RE: 316 Presumpscot Street

From: Barbara Barhydt [mailto:bab@portlandmaine.gov]
Sent: Tuesday, December 19, 2017 9:37 AM
To: Peter Biegel <pbiegel@landdesignsolutions.com>
Subject: 316 Presumpscot Street

STANDARD BOUNDARY SURVEY  
**PLAN OF PROPERTY**  
 PRESUMPCOT STREET PORTLAND, MAINE  
 made for  
**TIM O'DONOVAN**  
 30 LEDGEWOOD DRIVE FALMOUTH, MAINE  
 May 4, 1995  
**CULLENBERG LAND SURVEYING**  
 892 OLD DANVILLE ROAD  
 AUBURN, MAINE 04210  
 777-1150

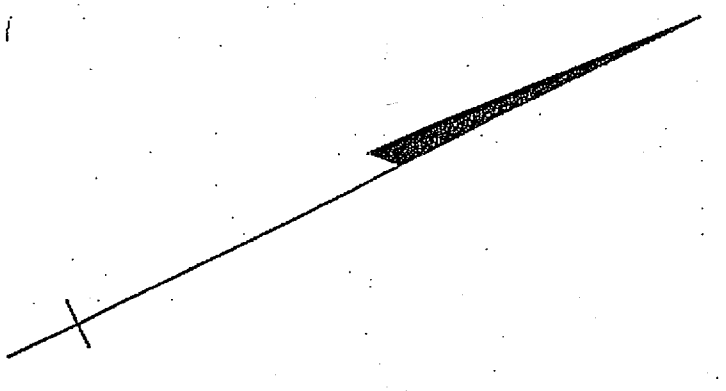
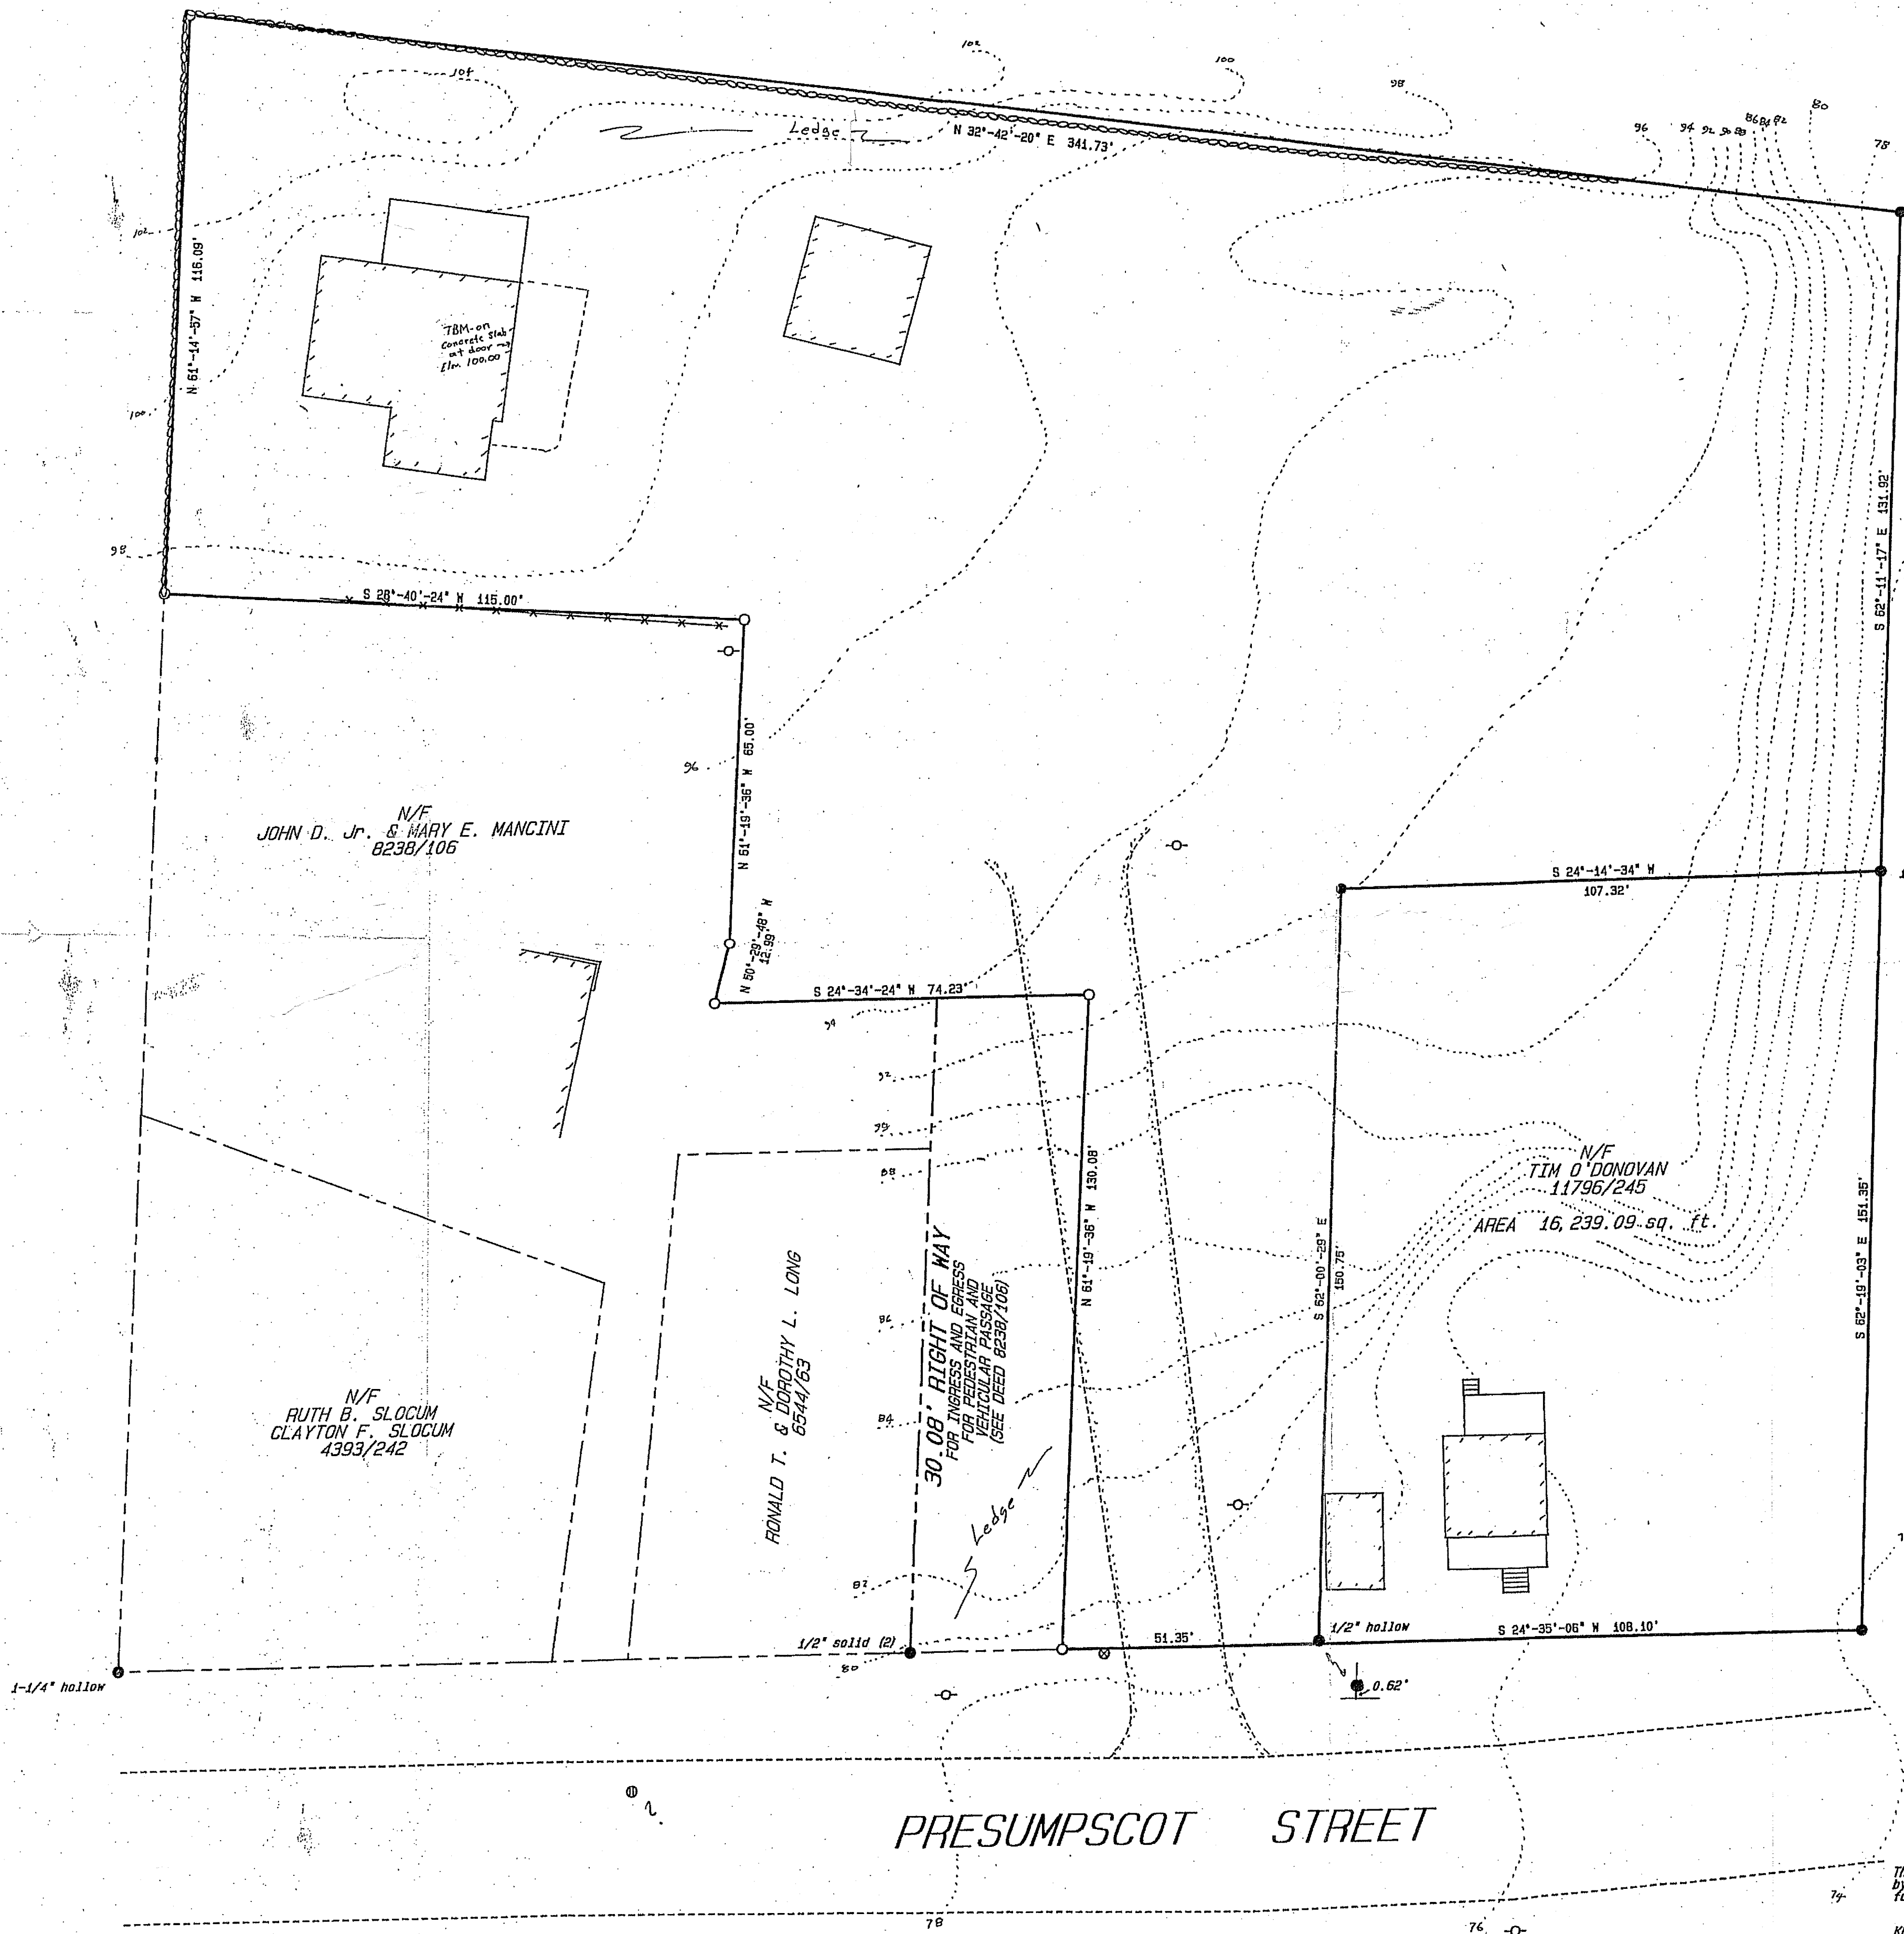
The survey submitted is dated 1994, as you noted in the submission. In looking at the aerials, the survey does not appear to be up to date and does not reflect the additional buildings and pavement that are currently on the site. The site plan does show the buildings, but the site plan is supposed to be based upon a recent survey. To complete the application, an updated survey is needed. When would this be available? **The 1994 survey is provided because that shows the Property Boundary and is sealed by Kevin Cullenberg a licensed land surveyor. As stated in note 4 of the site plan other existing conditions information which was needed was added to the site plan by the design team using a variety of methods such as field observations and measurements, aerial images and additional on the ground surveying by Cullenberg Surveying.**
